About the application

Application number: 2024/91501	
What is the application for?:	Erection of front porch (within a Conservation Area)
Address of the site or building:	16, Nabbs Lane, Slaithwaite, Huddersfield, HD7 5AU
Postcode:	HD7 5AU

4 PROPOSED FRONT ELEVATION  
1:50@A1

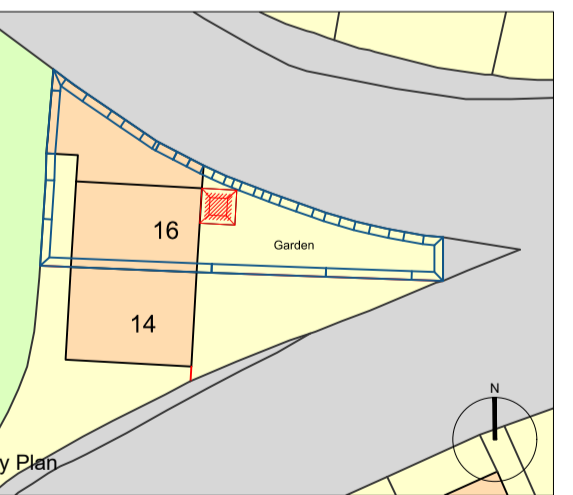
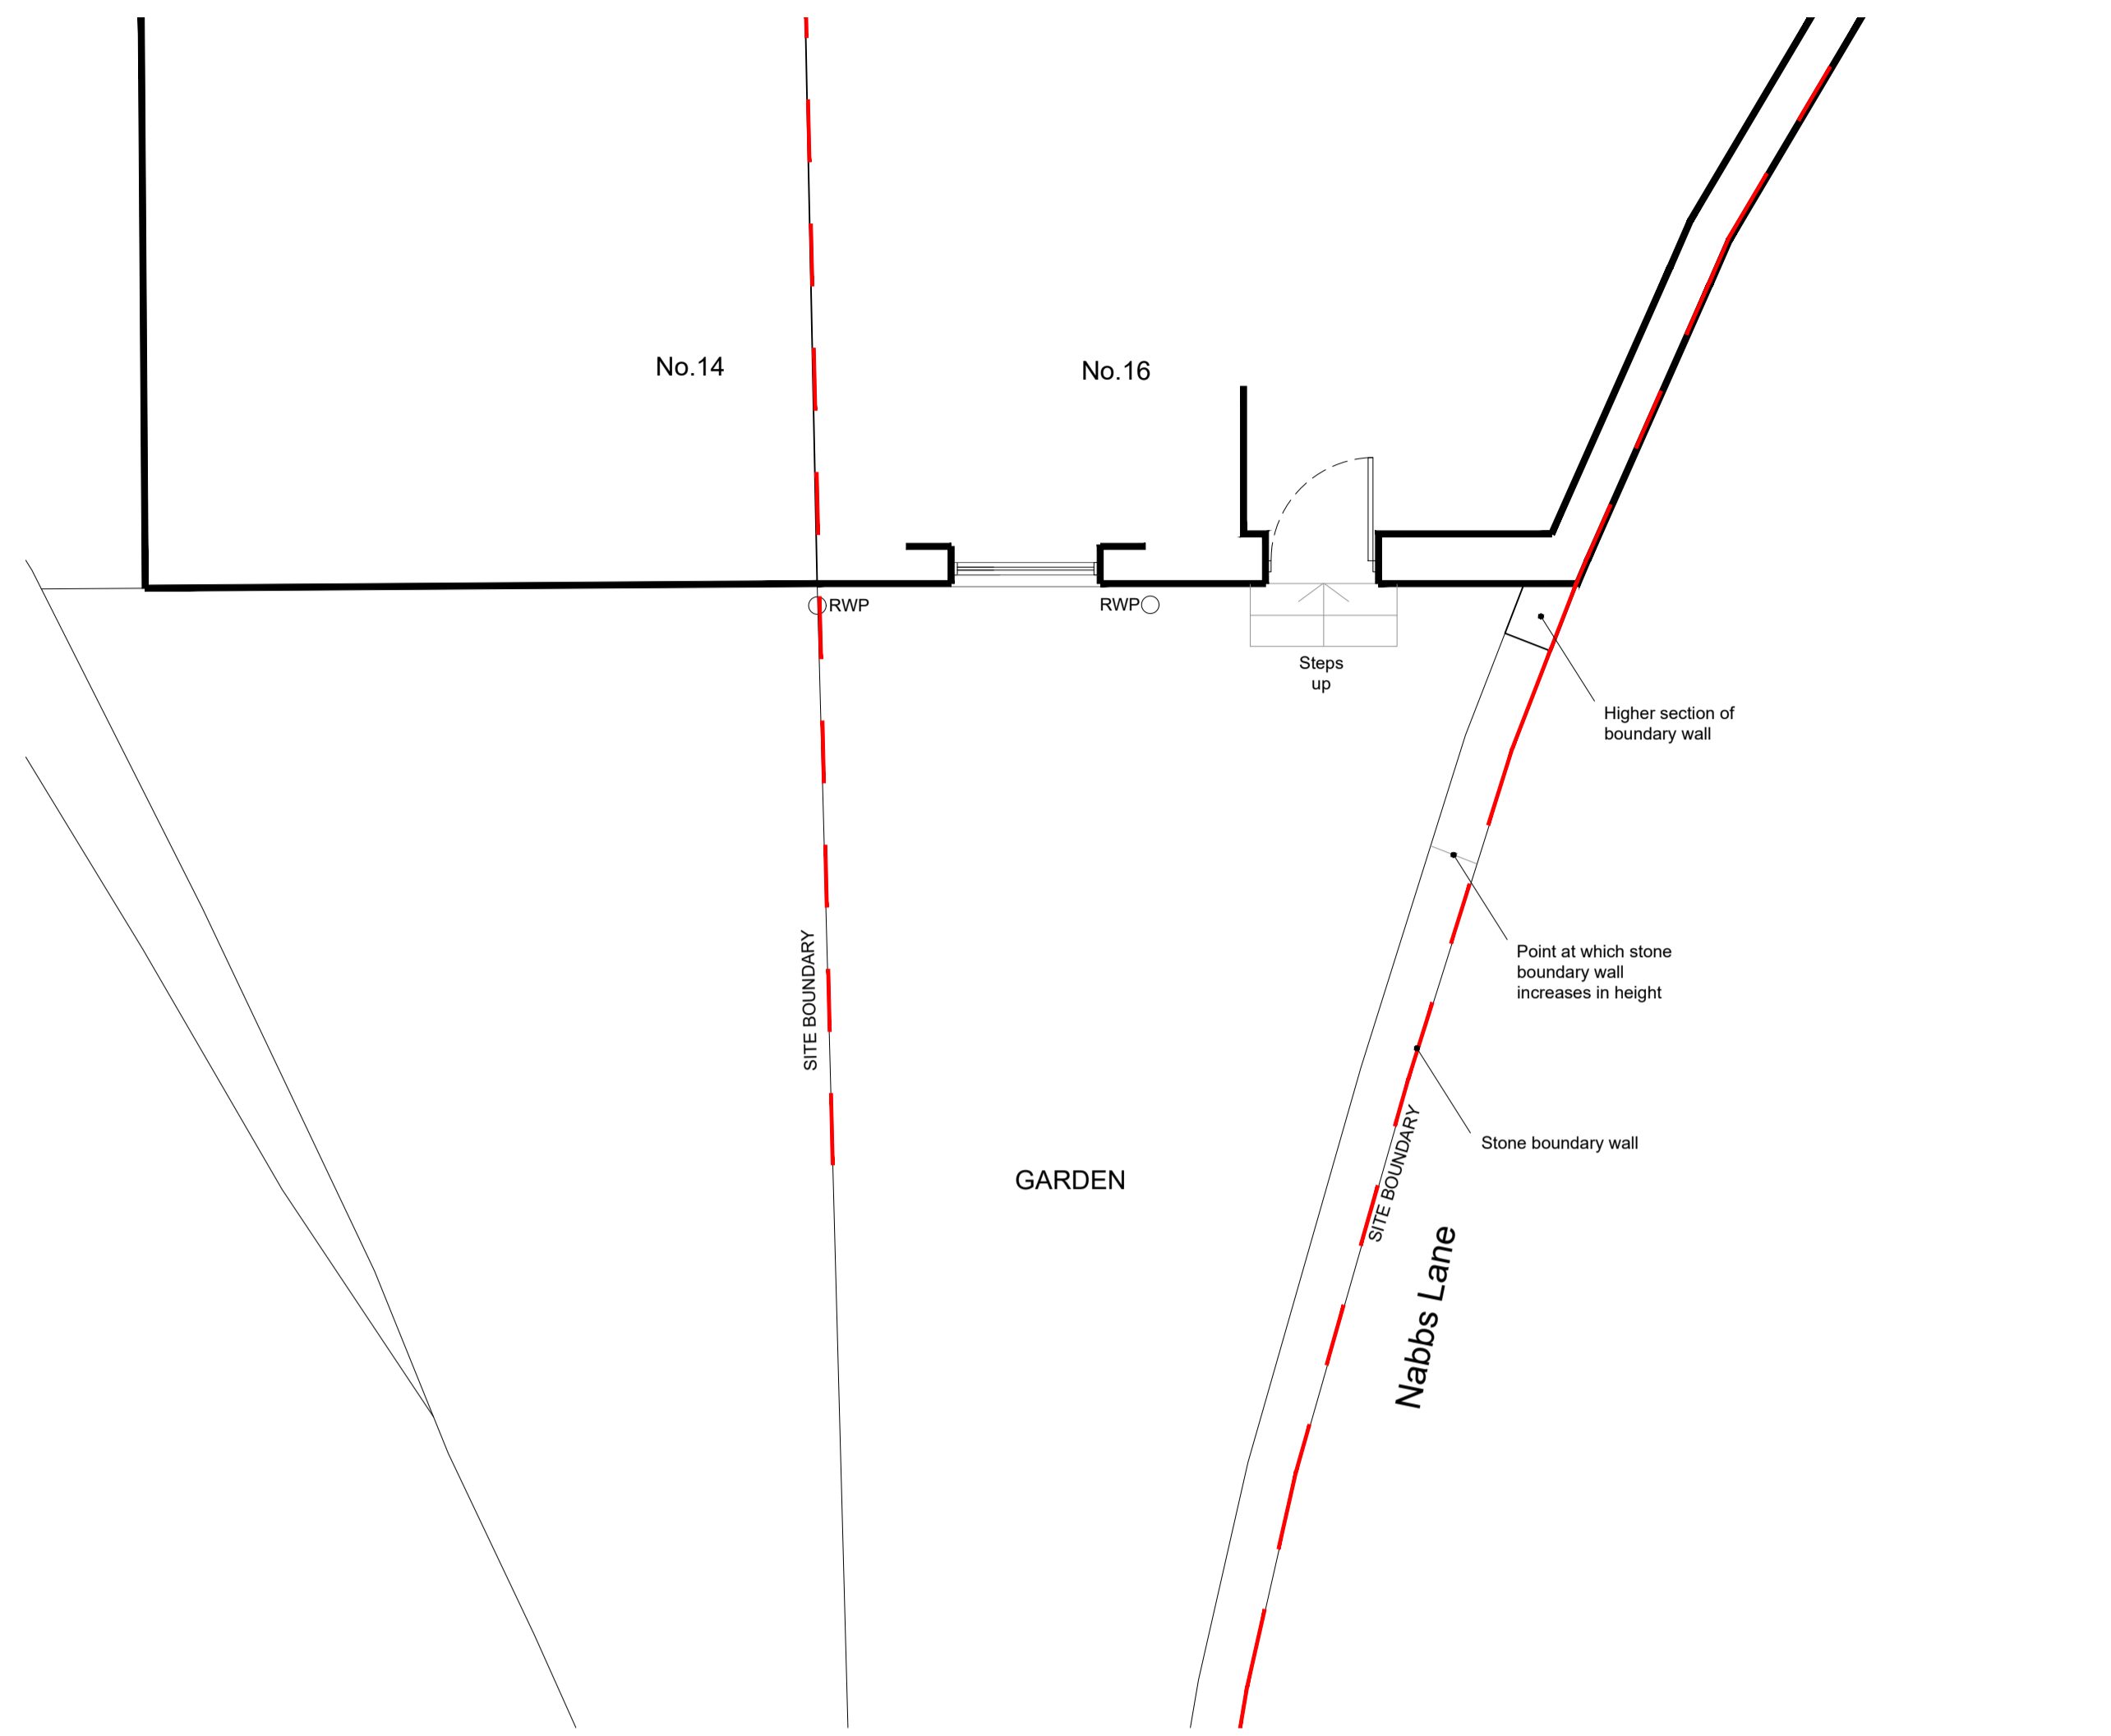
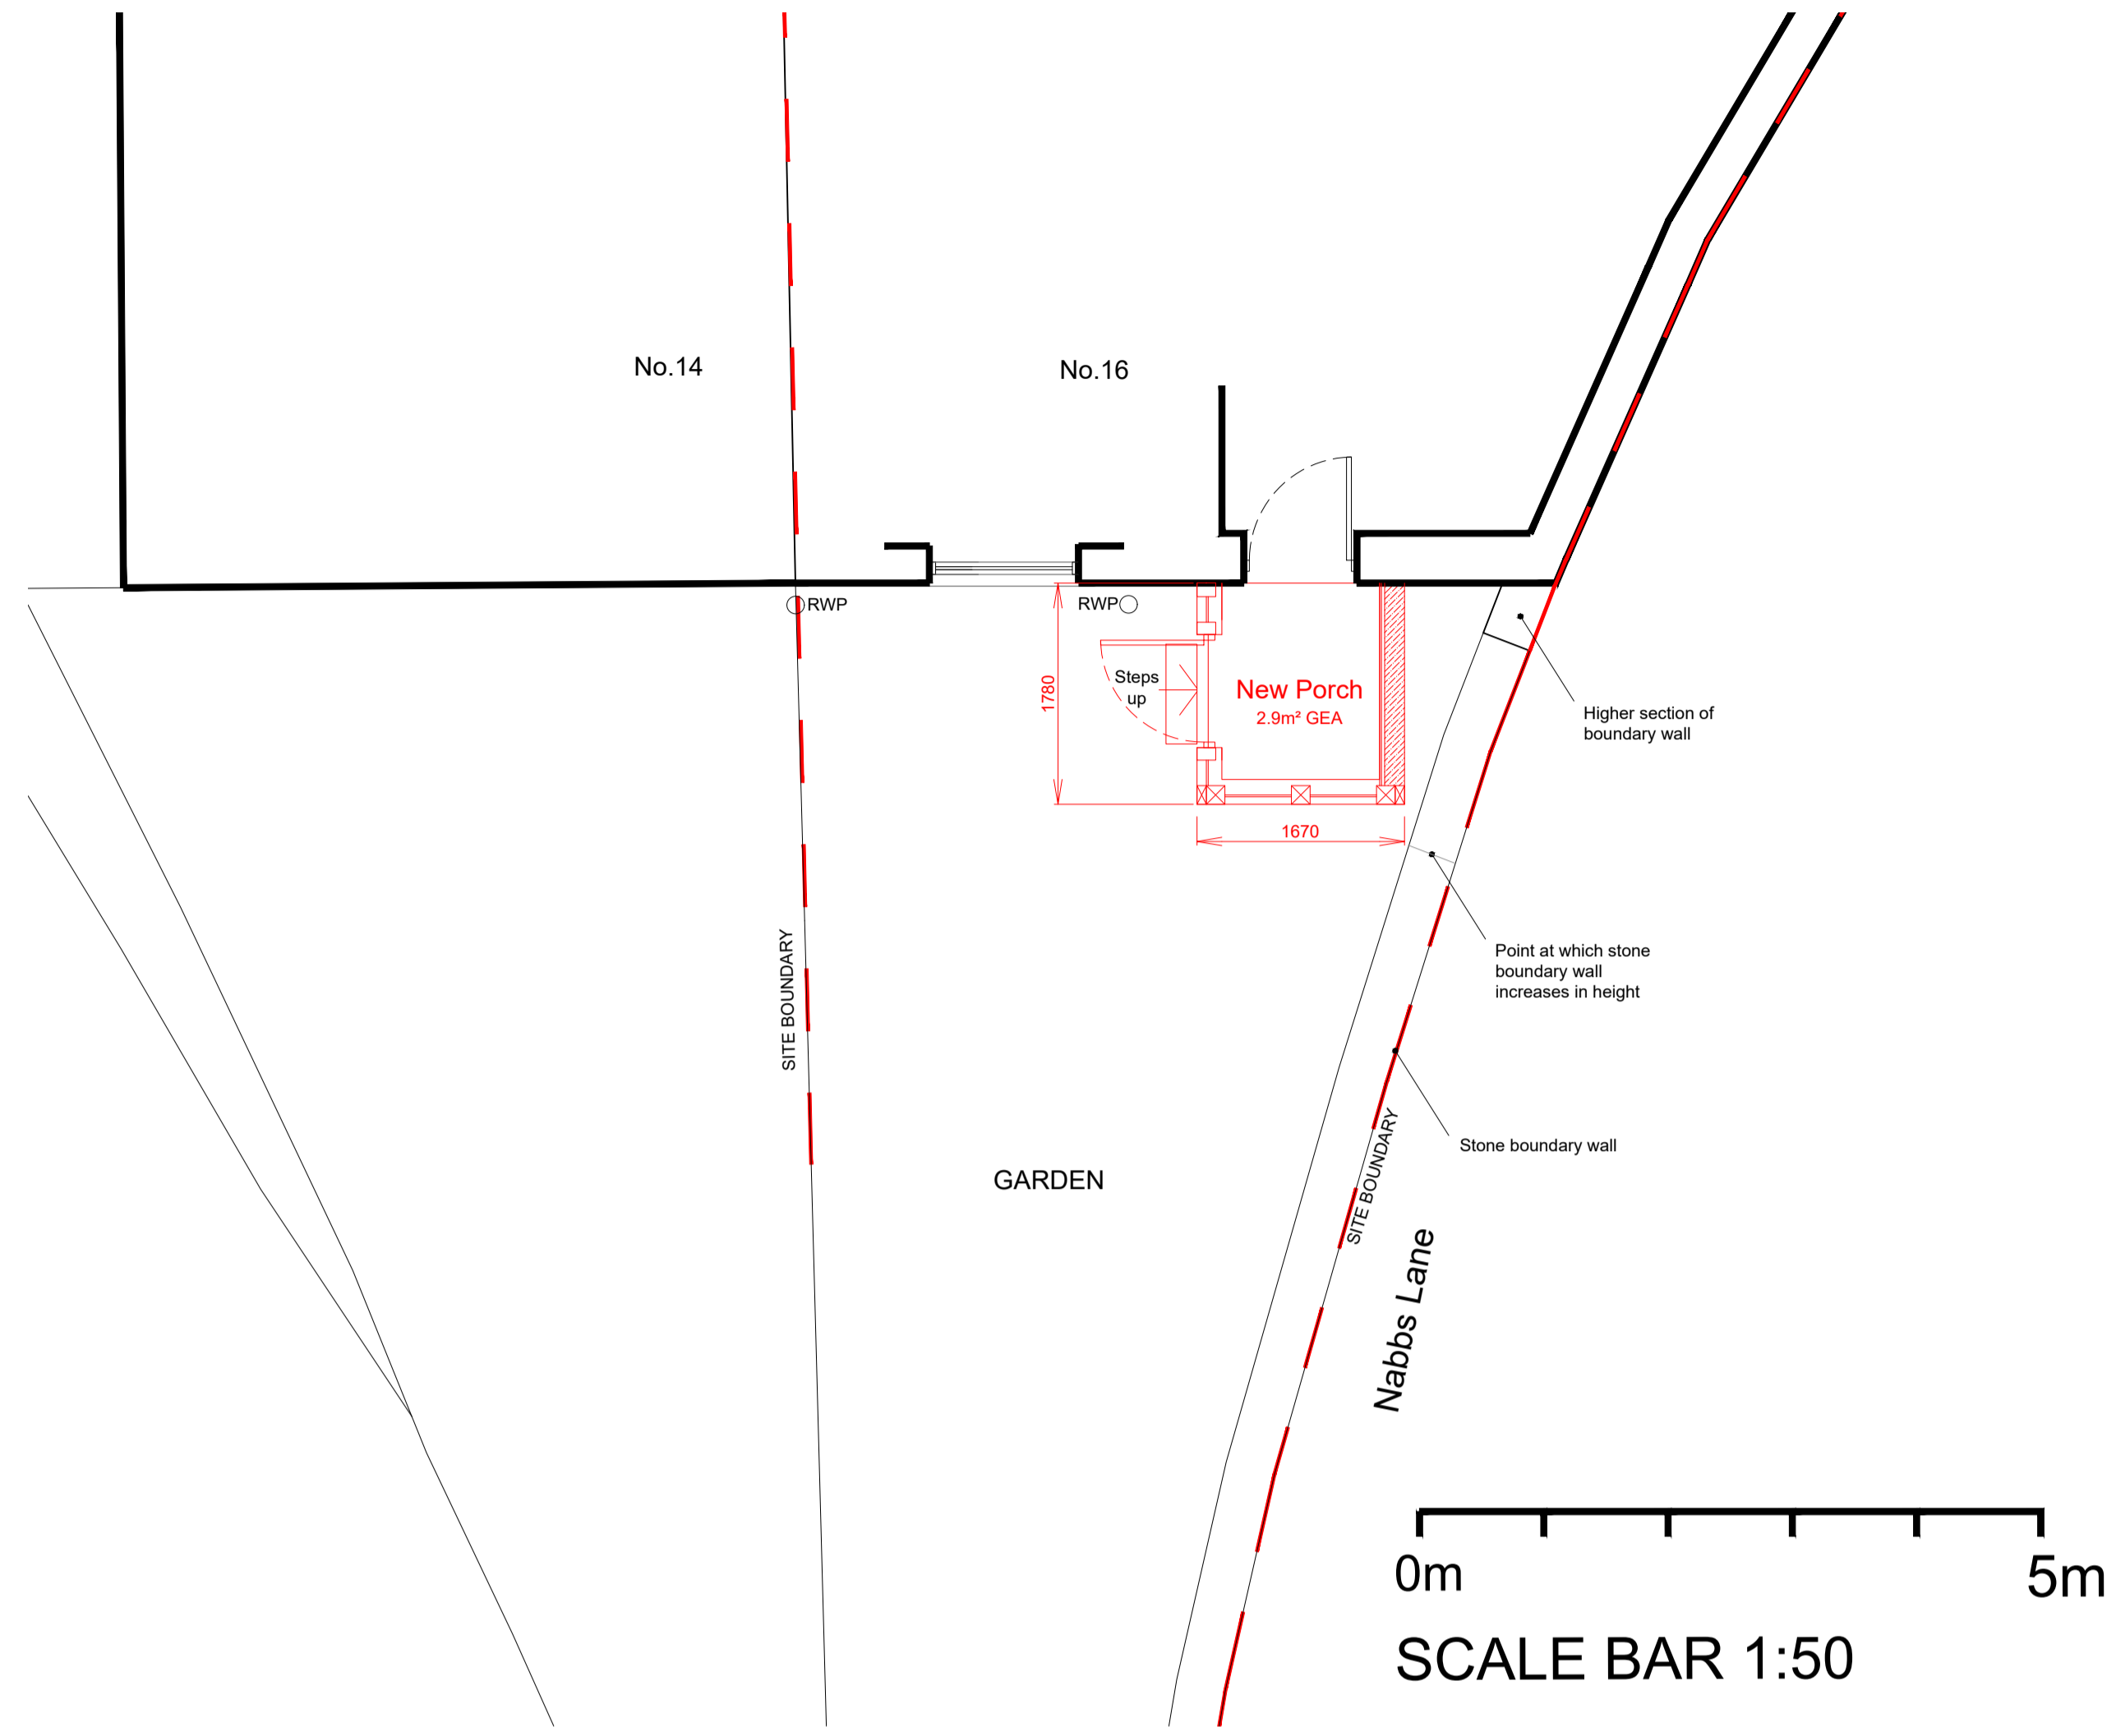
Type of comment: An objection	
Do you wish your comments to be published on the website anonymously?	Yes
Porch changed look of property and not consistent with identical semi next door no. 14 and does not blend or fit in with house attached nor the area. It is too high and the door from porch is not front facing as it was originally and is now to the side facing front garden to no. 14.
